Please ask for: Nicola Moore
Email: nicola.moore@arun.gov.uk
Telephone: Ext 37944
Our Ref: A/55/20/CLP
Your Ref:
Date: 8th April 2020

Lawful Development Certificate for a Proposed Use or Development

Development: Lawful development certificate for a single storey rear extension.
Location: Ariston Water Lane Angmering BN16 4EJ

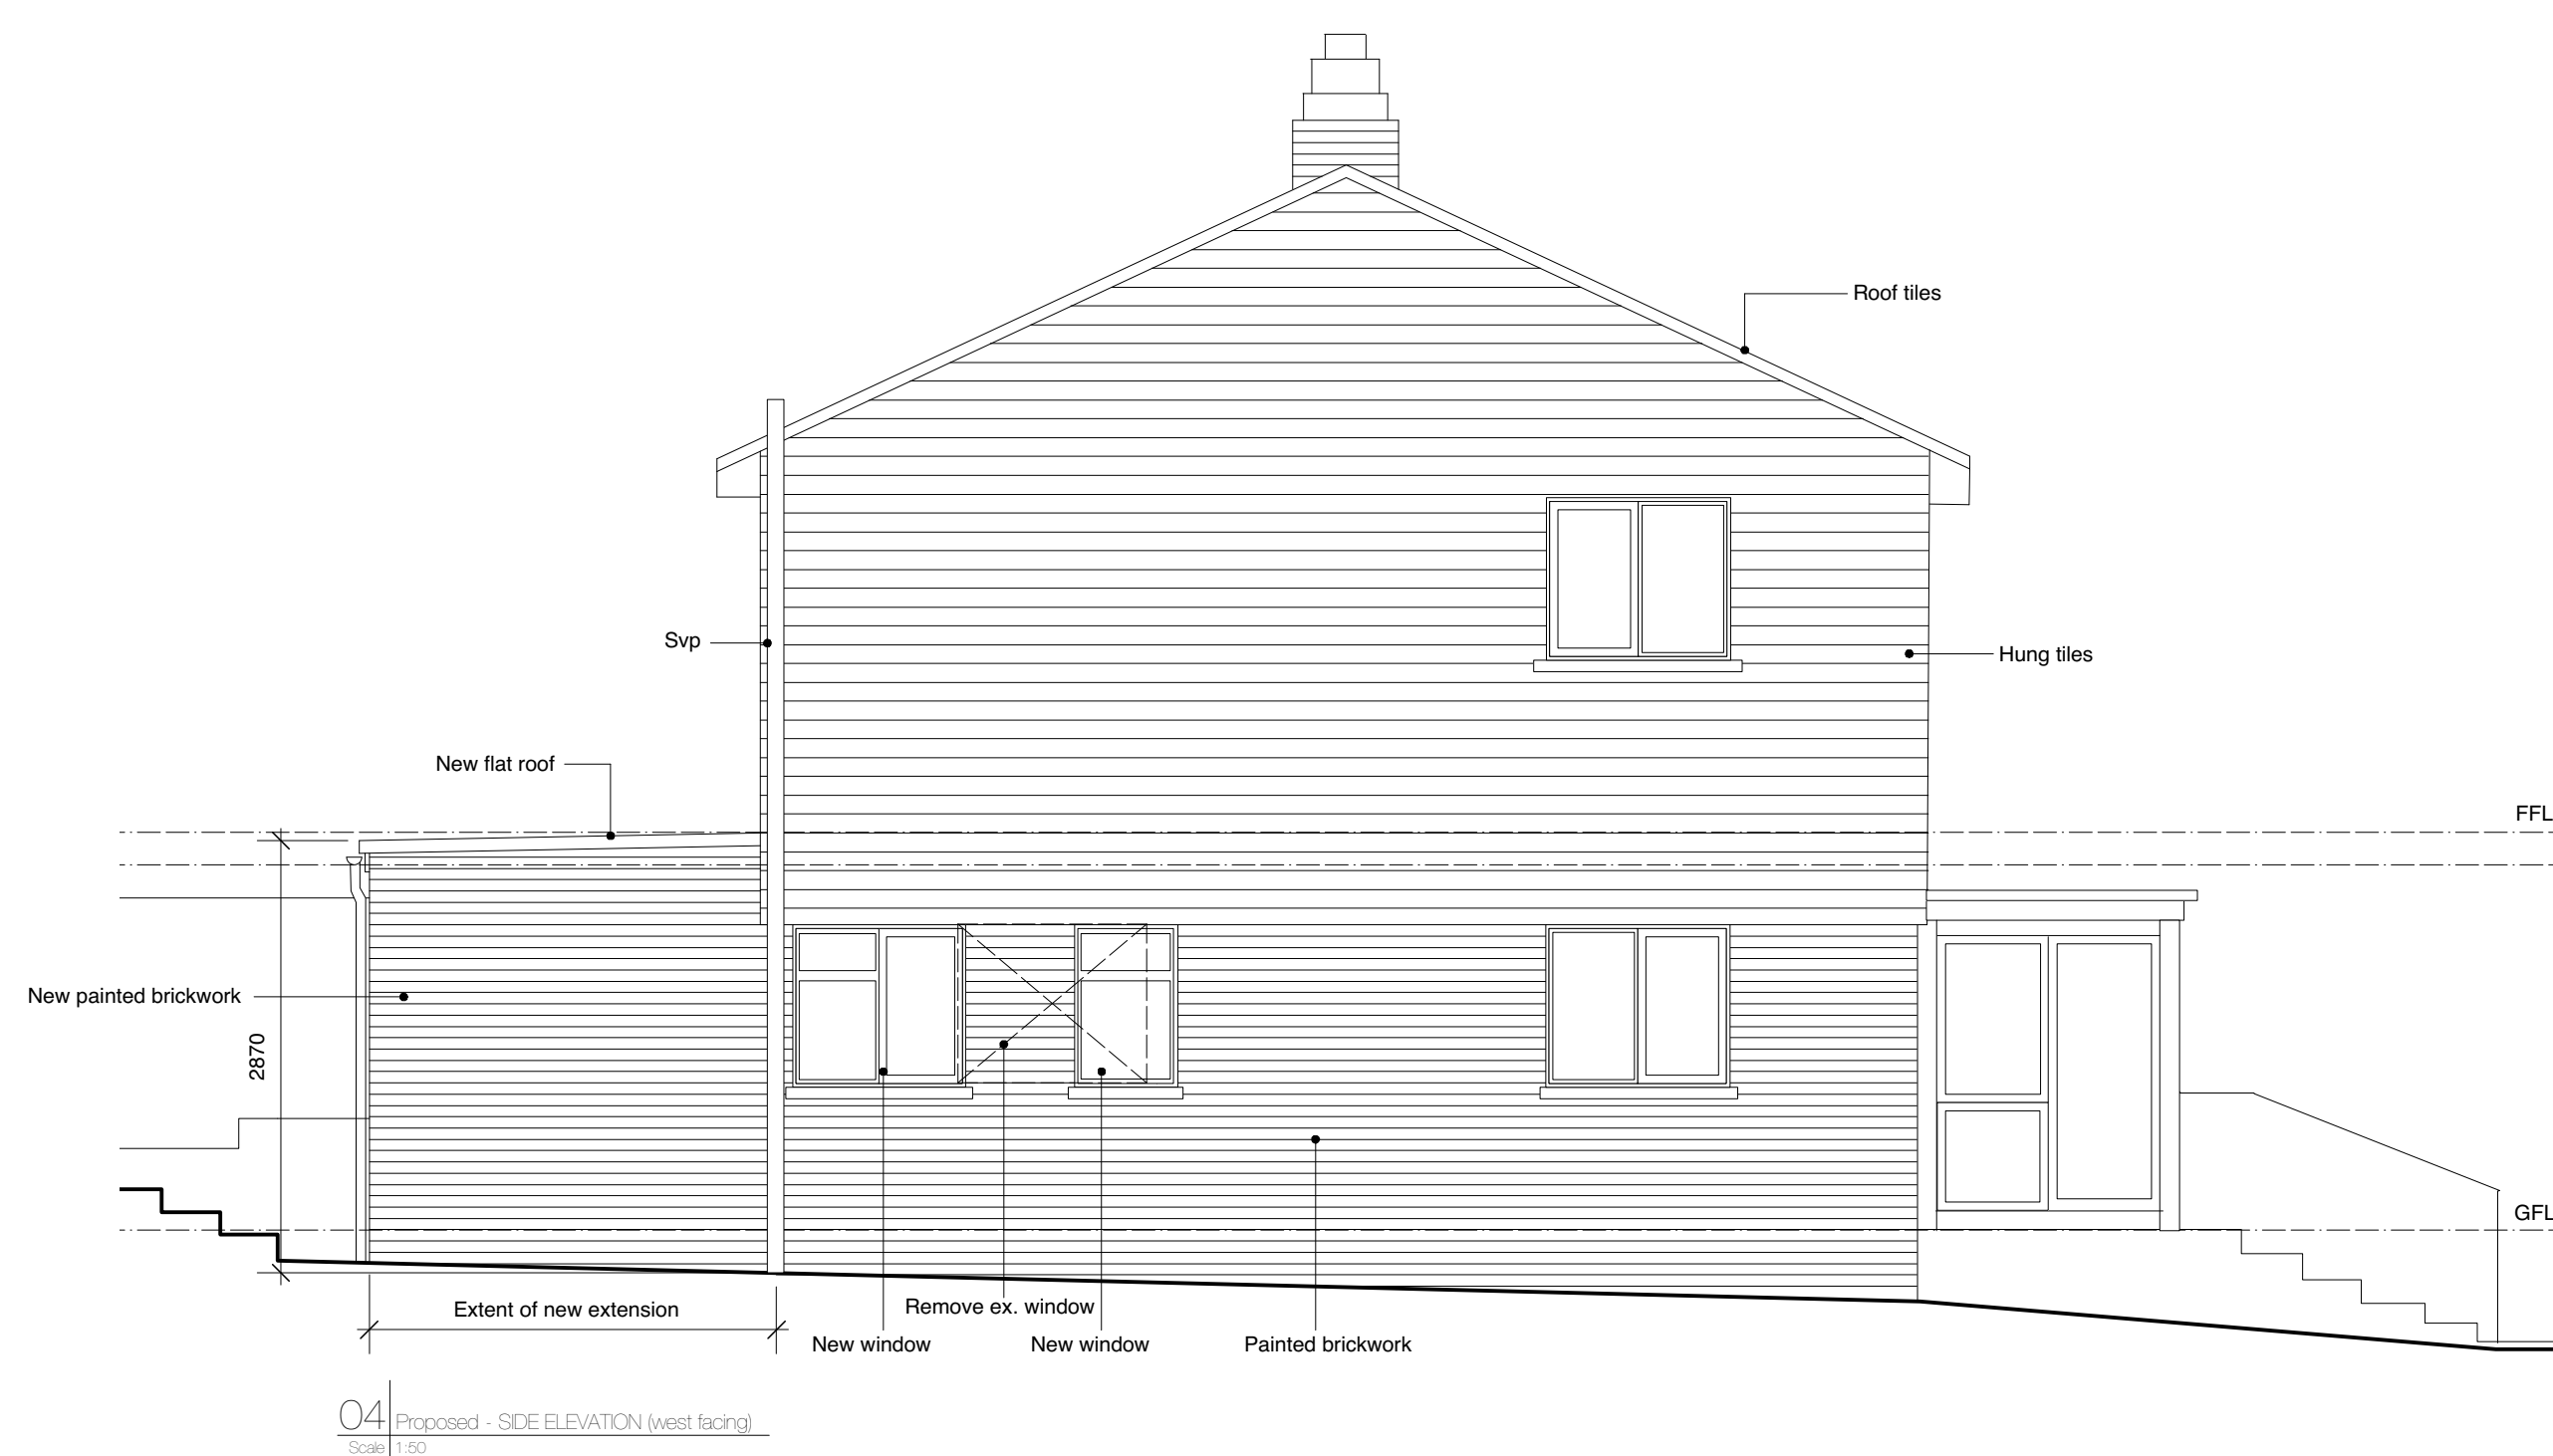
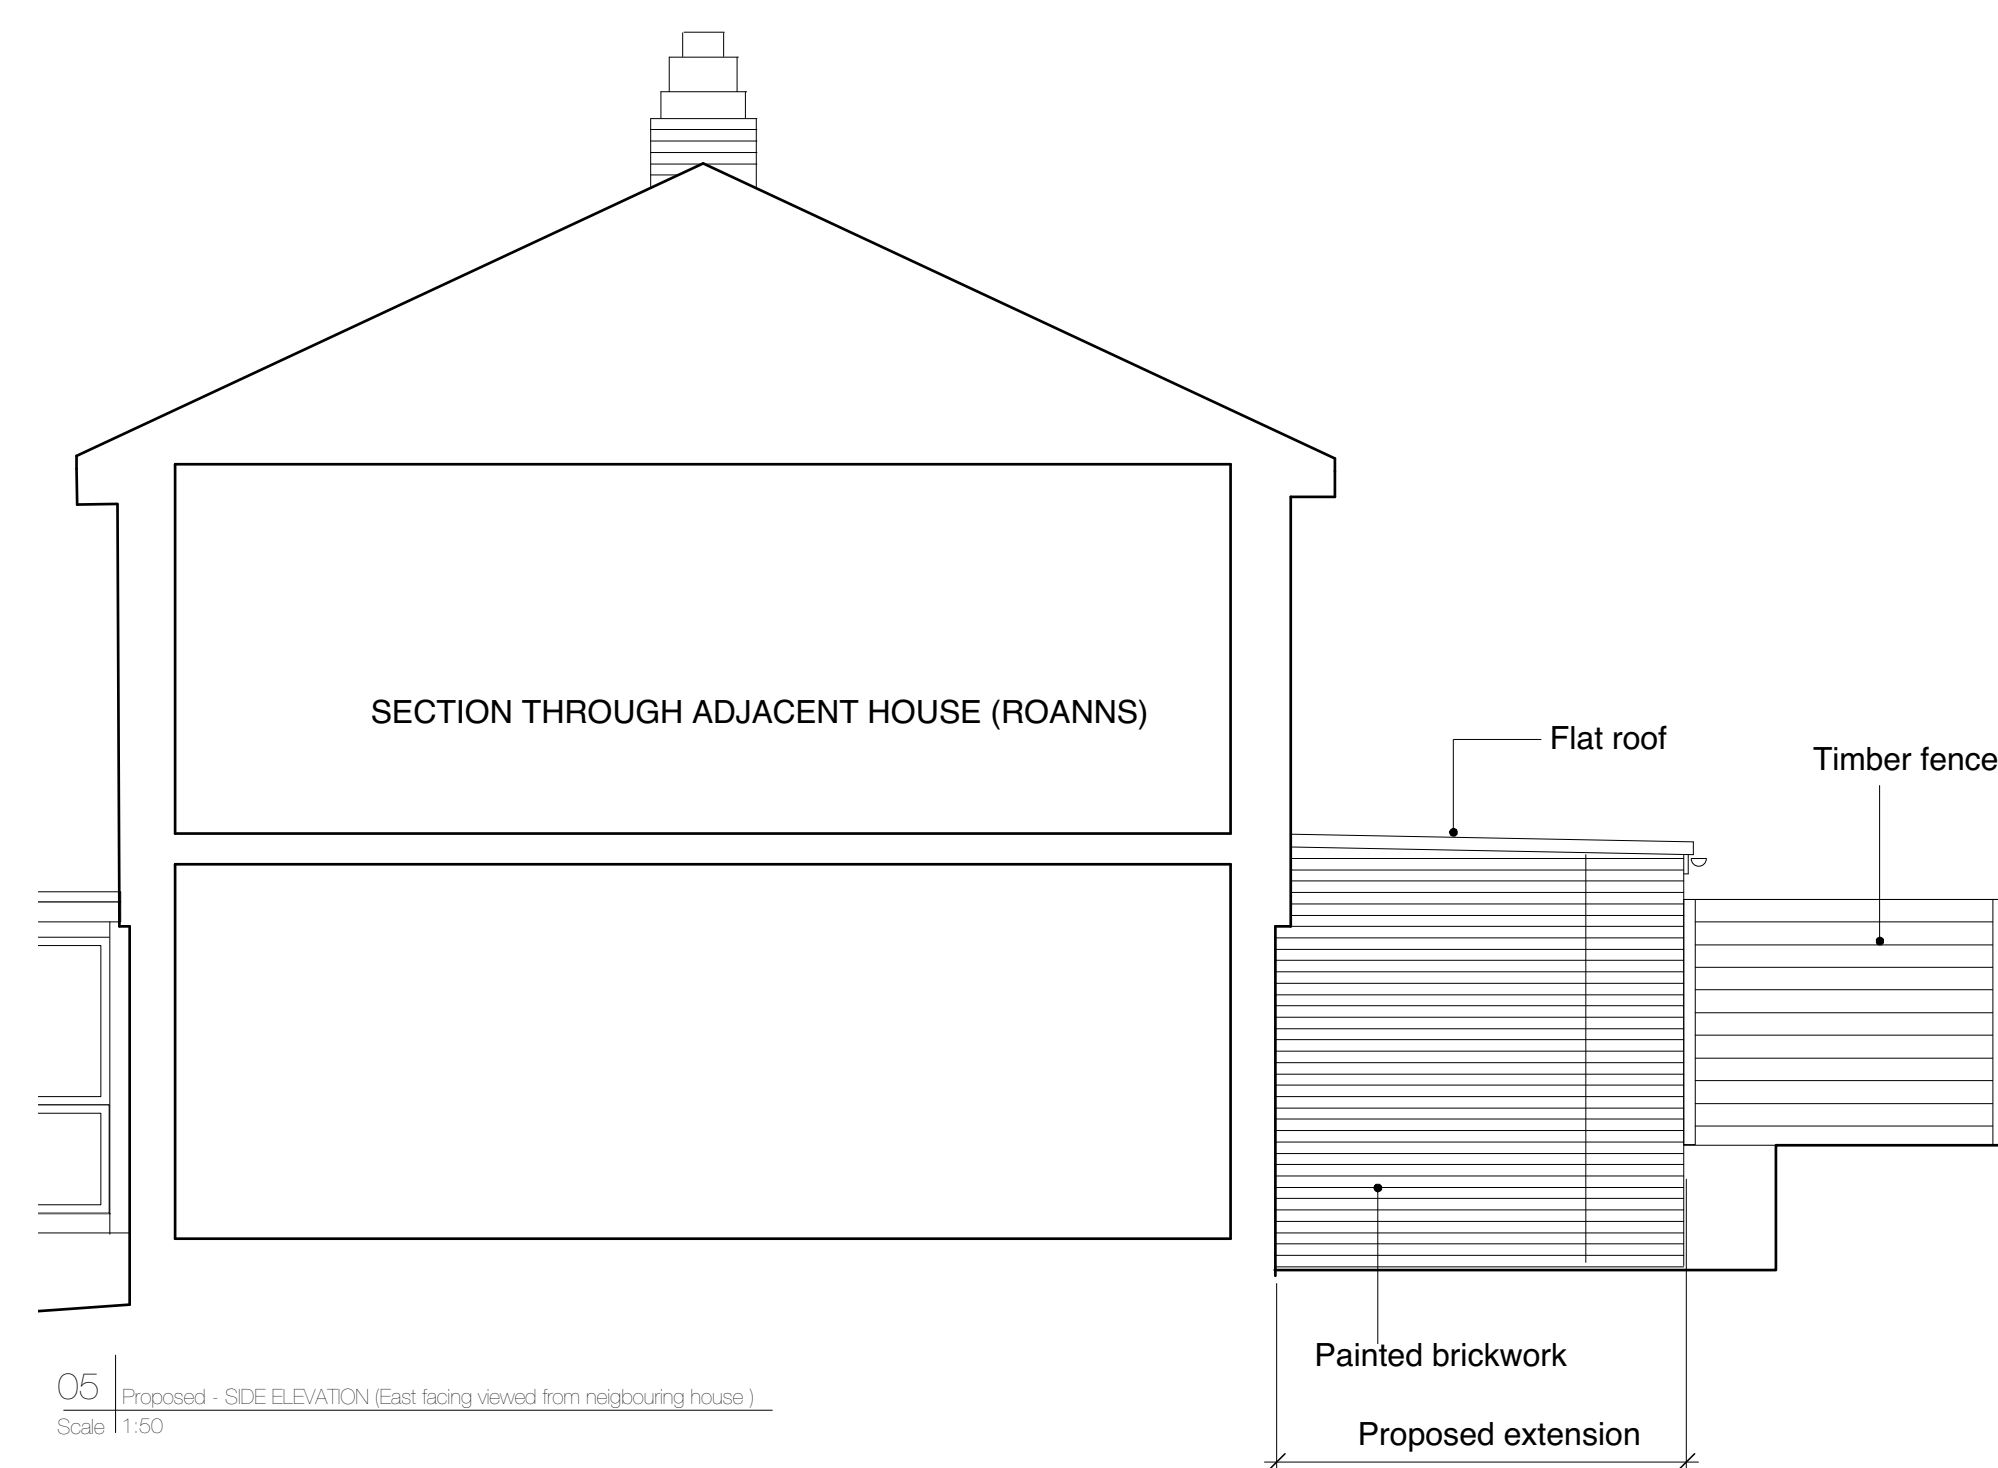
I have measured the bathroom window at 0.9m on the proposed first floor plan and 1.05m on the proposed elevation. Please could you check the measurements, and amend/confirm accordingly.
